Exhibit A-2
Initially Included Property Map

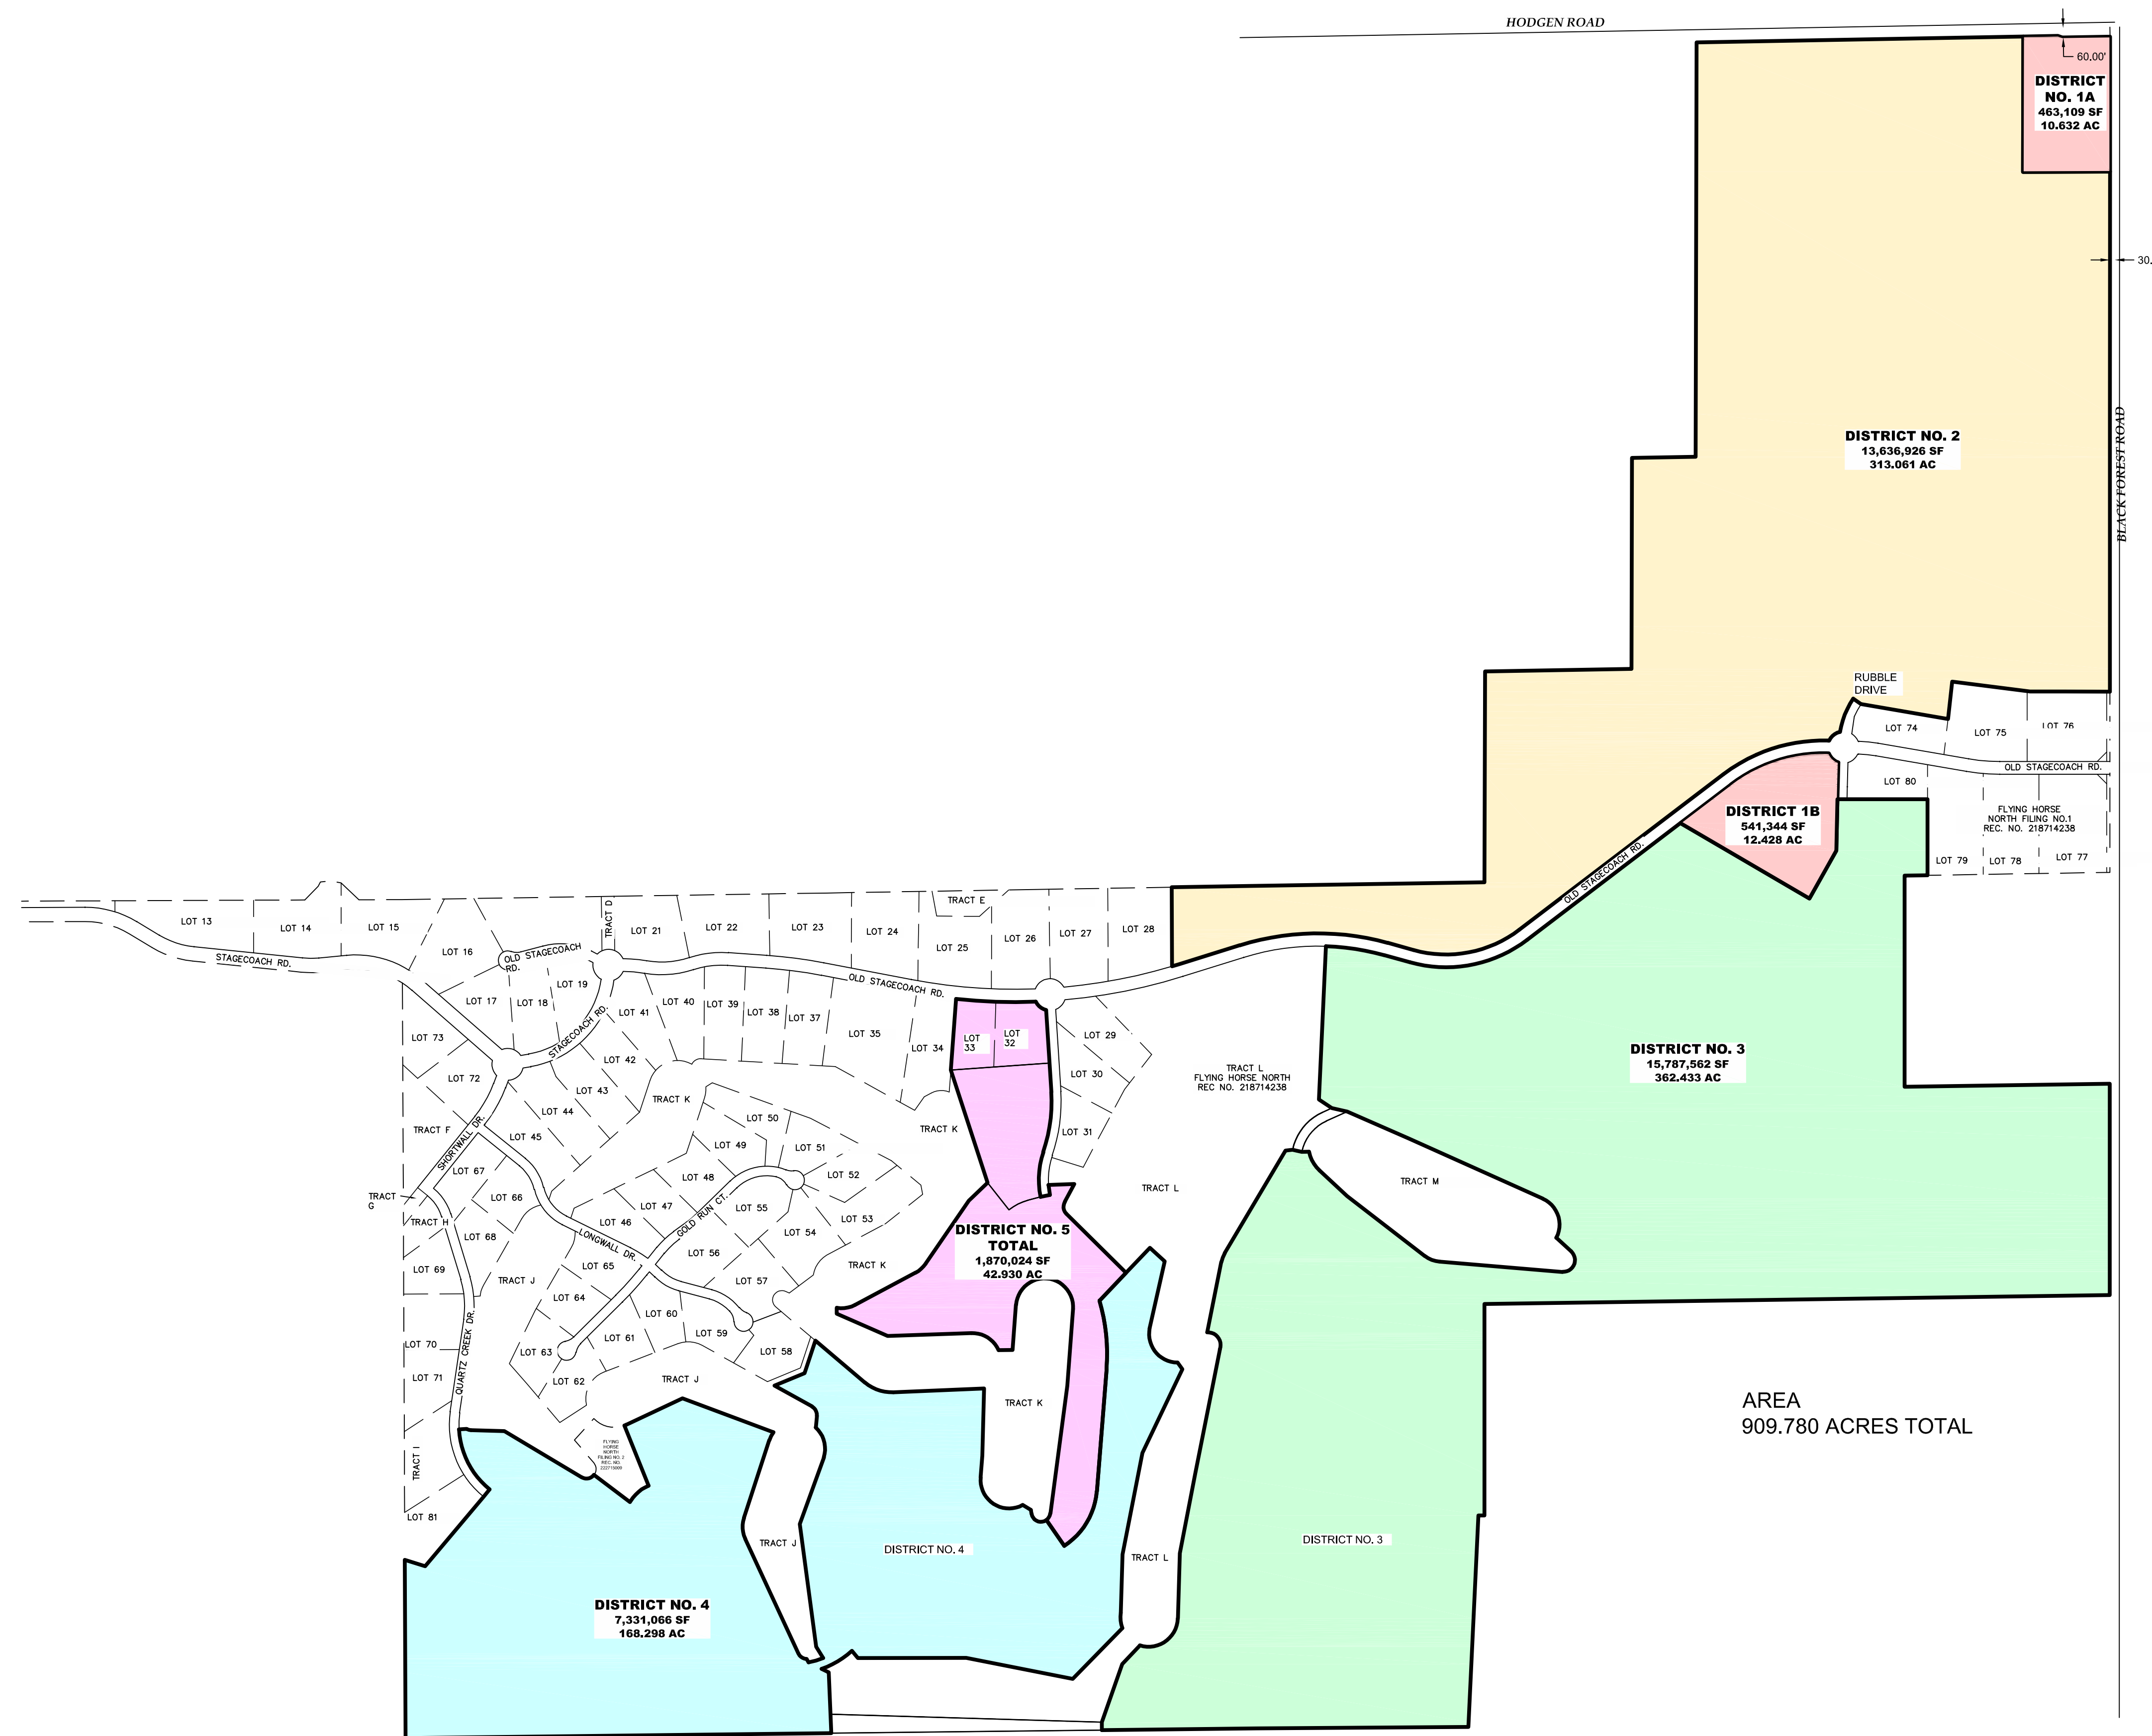
1.	Exhibits Page – Provide map depicting where existing Districts are and where these are proposed, any areas to be excluded.	Exhibit A-2, the Initially Included Property Map, was revised to include the existing Flying Horse Districts. The existing Flying Horse Districts are not in the immediate vicinity of the new Flying Horse North Districts. The property

17.	VII.B. – Donald Wescott Fire Northern Subdistrict may be dissolved.	Noted.
18.	Exhibit A-1 – Subdistricts were not mentioned in service plan; show existing Districts 1-3	There will not be subdistricts. Exhibit A-2 includes a map with the existing districts in relation to the new districts.

19.	Exhibit A-2 – Include legend	Revised
EPC PROJECT MANAGER LETTER OF INTENT COMMENTS		
1.	A. - Include brief purpose of each district.	Revised
2.	A. – Are members only private clubs eligible for District money?	This was an error and has been revised; the Districts are not financing or constructing the golf course or golf clubhouse.

within the new Flying Horse North Districts was never located within the boundaries of the existing Flying Horse Districts which are in the City of Colorado Springs and could not include the Flying Horse North property which is in the County.
